**SASSE RIDGE PLAT (LP-11-00002)
COMPLIANCE DOCUMENT**

JANUARY 22, 2013	RECOMMENDED FINDINGS OF FACT, CONCLUSIONS OF LAW, DECISION AND CONDITIONS OF APPROVAL - ANDREW KOTTKAMP, HEARING EXAMINER	1. ALL CONDITIONS IMPOSED HEREIN SHALL BE BINDING ON THE "APPLICANT," WHICH TERMS SHALL INCLUDE THE OWNER OR OWNERS OF THE PROPERTY, HEIRS, ASSIGNS AND SUCCESSORS. 2. THE PROJECT SHALL PROCEED IN SUBSTANTIAL CONFORMANCE WITH THE PLANS AND APPLICATION MATERIALS ON FILE DATED AUGUST 17, 2011 EXCEPT AS AMENDED BY THE CONDITIONS HEREIN. 3. A CERTIFICATE OF TITLE OF THE PROPERTY PROPOSED TO BE PLATTED SHALL BE SUBMITTED WITH THE FINAL PLAT. 4. A NOTE SHALL BE PLACED ON THE FINAL PLAT STATING THAT ANY CONSTRUCTION WITHIN AREAS OF 33% OR GREATER SLOPE WILL REQUIRE GEOTECHNICAL ENGINEERING PER IRC R403.7.7 AND/OR IRC 1805.3.1 OR CURRENT ADOPTED CODE. 5. THE APPLICANT IS RESPONSIBLE FOR COMPLIANCE WITH ALL APPLICABLE LOCAL, STATE AND FEDERAL RULES AND REGULATIONS, AND MUST OBTAIN ALL APPROPRIATE PERMITS AND APPROVALS. 6. ALL CURRENT AND FUTURE LANDOWNERS MUST COMPLY WITH THE INTERNATIONAL FIRE CODE. 7. IT IS THE RESPONSIBILITY OF THE APPLICANT TO CONTACT THE KC ASSESSOR'S AND TREASURER'S OFFICE TO C

SASSE RIDGE PLAT

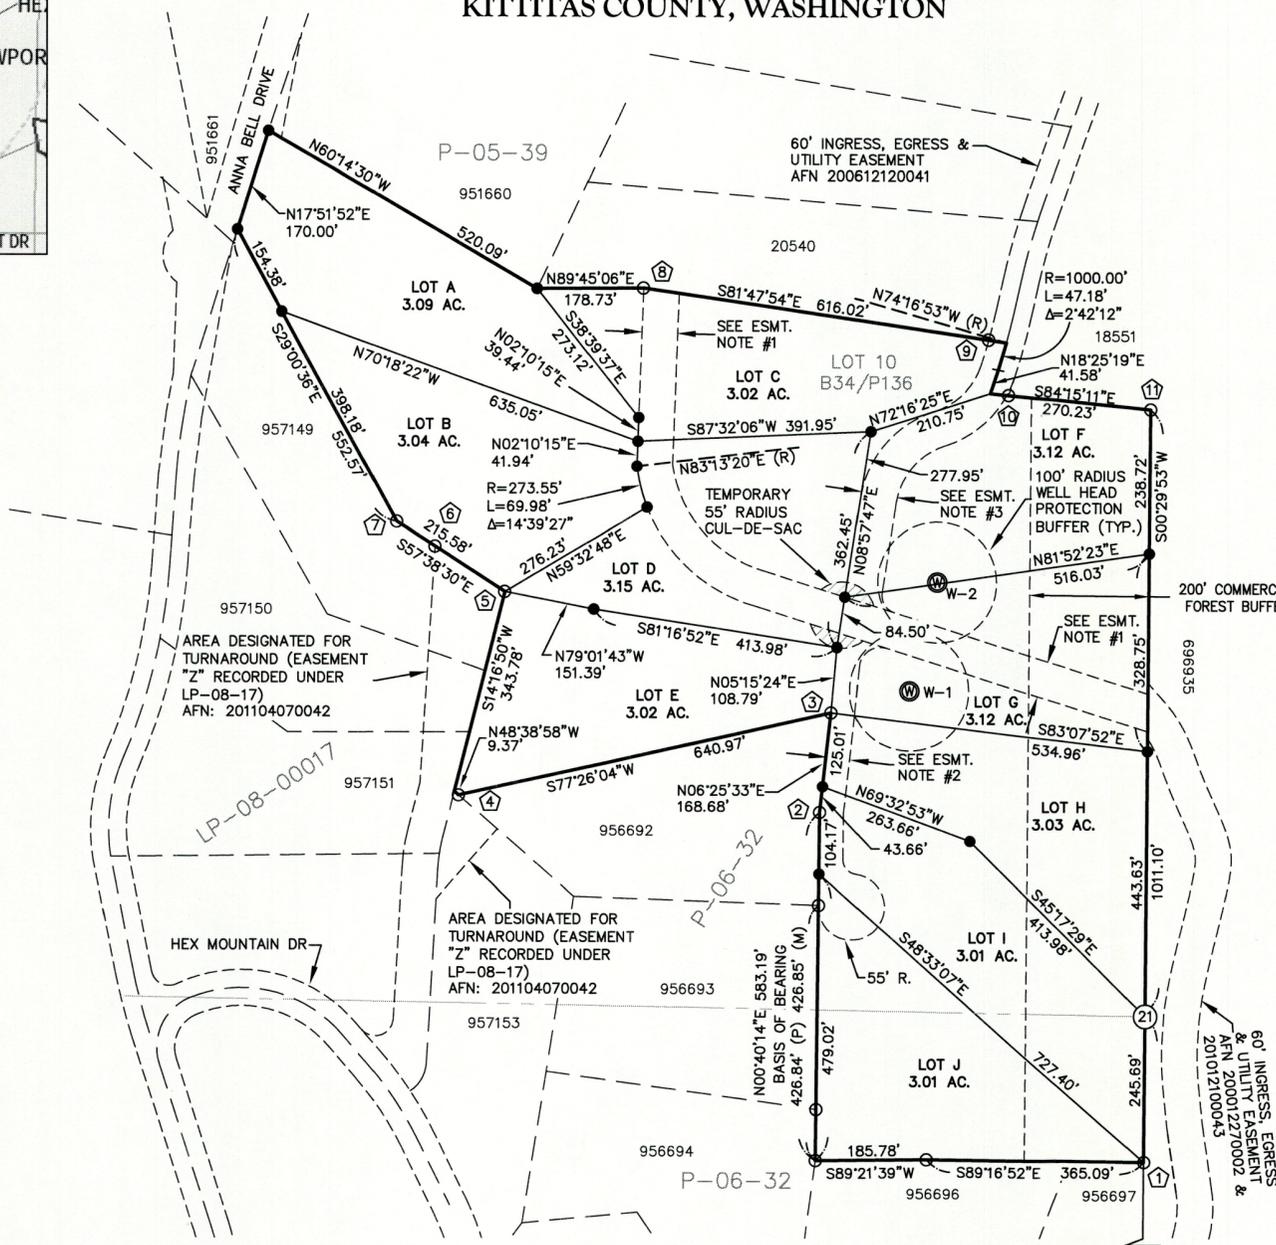
M. CONTOURS. CONTOUR LINES ARE NOT SHOWN ON THE FINAL PLAT AS REQUIRED ON THE PRELIMINARY PLAT;	Contour lines have been removed from the final plat.
